Gatwick Airport Northern Runway Project

Examination Ref: TR020005

Joint Local Authorities Response to the Applicants Deadline 4 Submissions and response to the Applicants Written summary of oral submissions ISH6. ISH7 and CAH1

Deadline 5: 6 June 2024

Drawn date:
September 2023

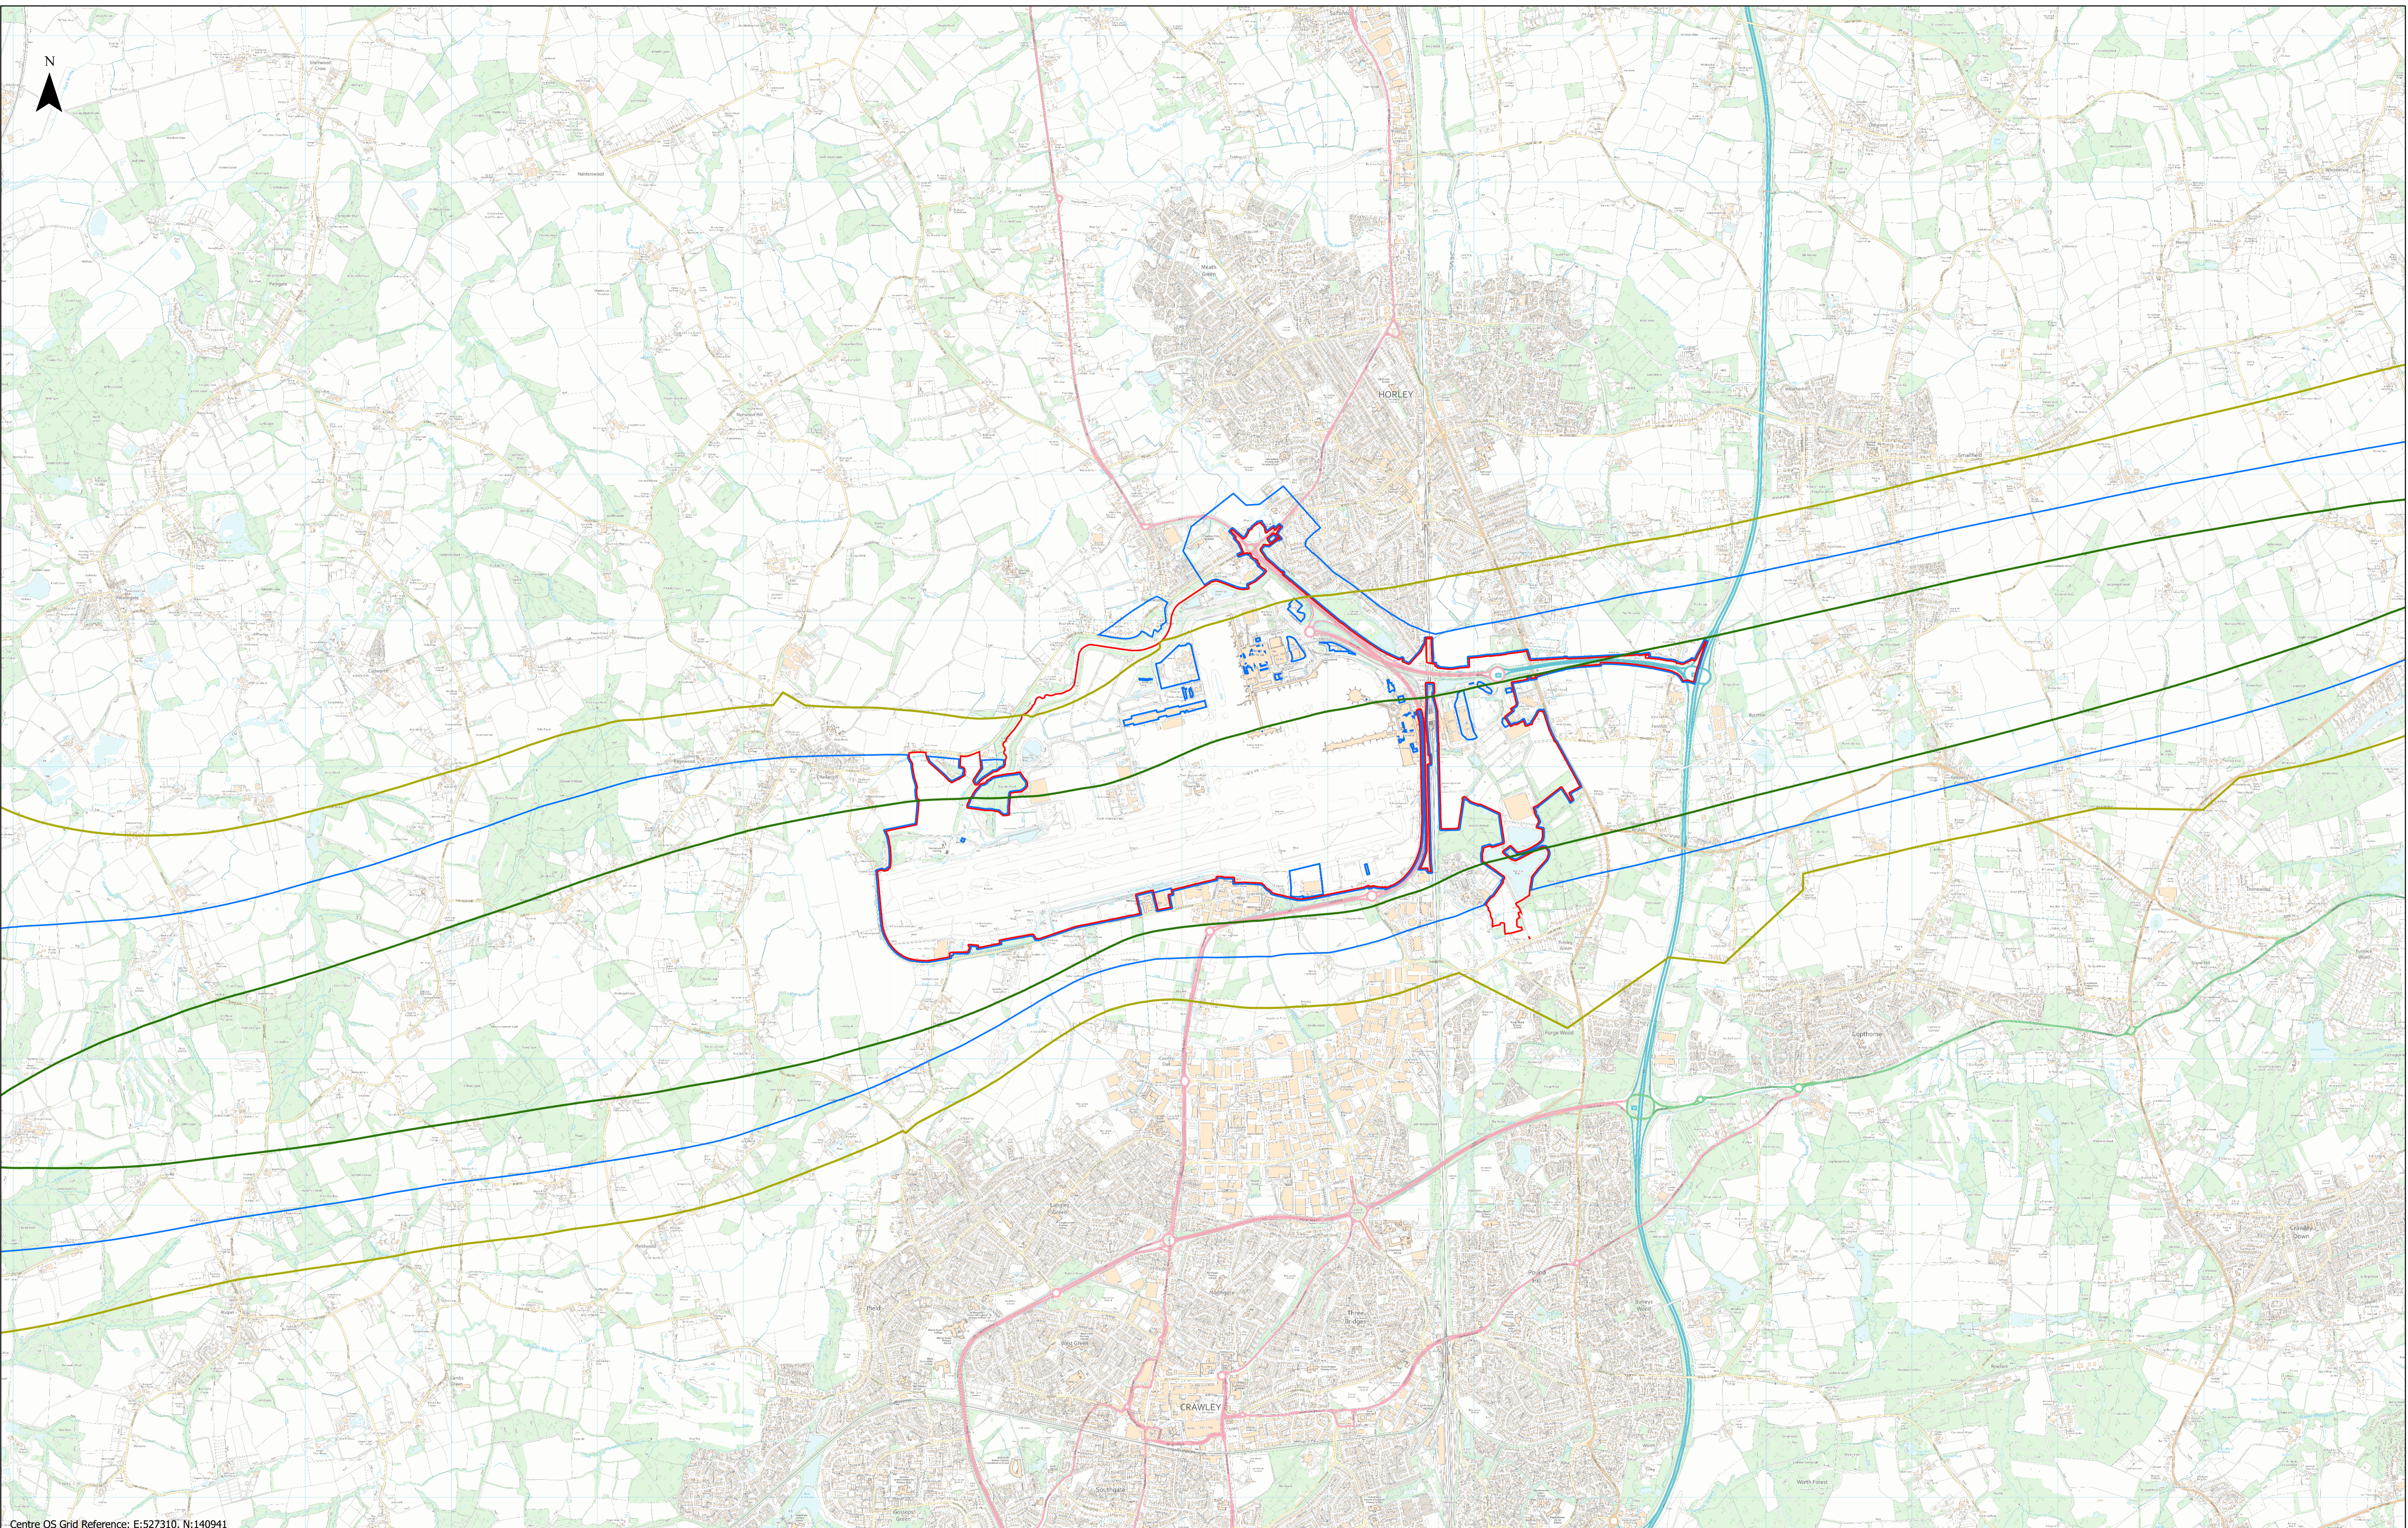
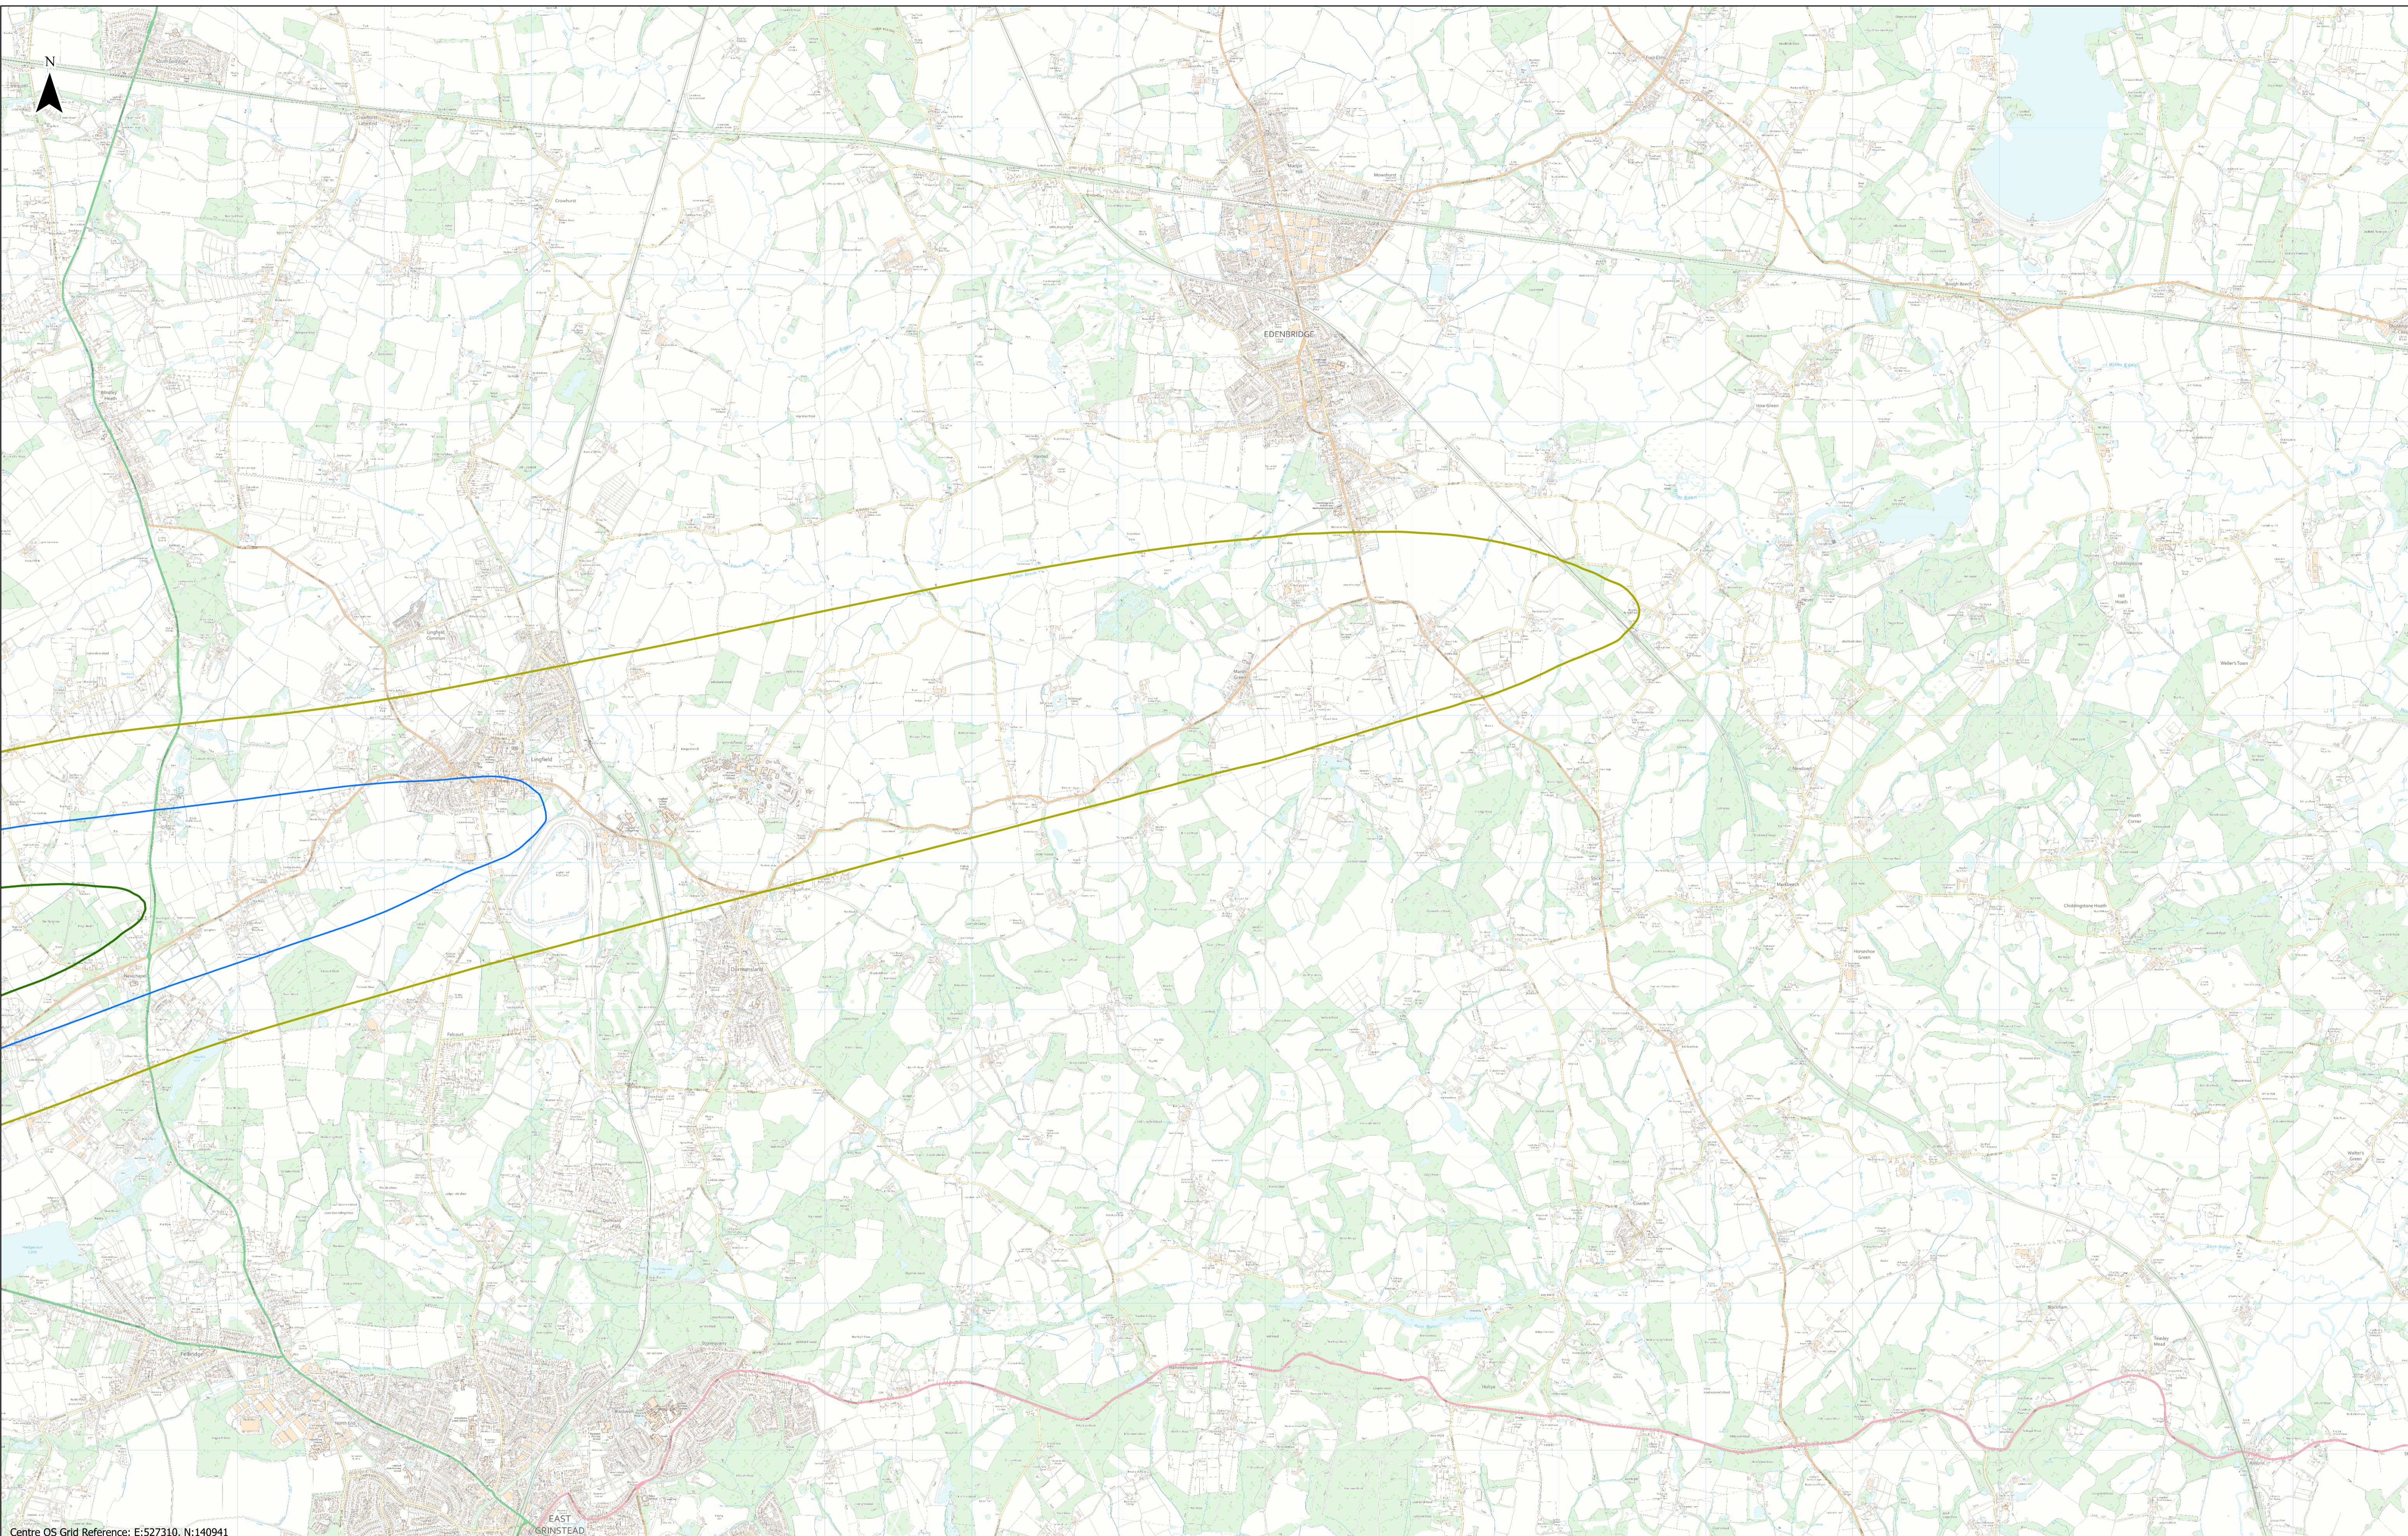
- 3.9 The JLAs believe that the scheme should be based on the single mode contours. The designation of the extent of the inner and outer zones should be by agreement with the Local Planning Authority. Rather than rely on the precise extent of a polygon on a geographic information system produced by a model, the extent of the insulation zone should be adjusted to take into account the extent of any built up areas and the zone extended accordingly. This adjustment existed under the previous scheme but it appears to have been mostly dropped under the current proposal.

- 3.10 In addition to the general points above the JLAs make comment about specific paragraphs below.
- Eligibility for ground noise insulation should be included in the Outer Zone. Ground noise eligibility should be based on ground noise predictions so insulation can be provided before significant effects occur.

- What noise contours will eligibility for the noise insulation scheme be based on?
- Paragraph 4.1.4. The JLAs consider that as an average 8 hour night value, when taken over the 92 day summer period, the one additional noise induced awakening due to aircraft noise must also be set as the extent of the inner zone for noise insulation purposes.
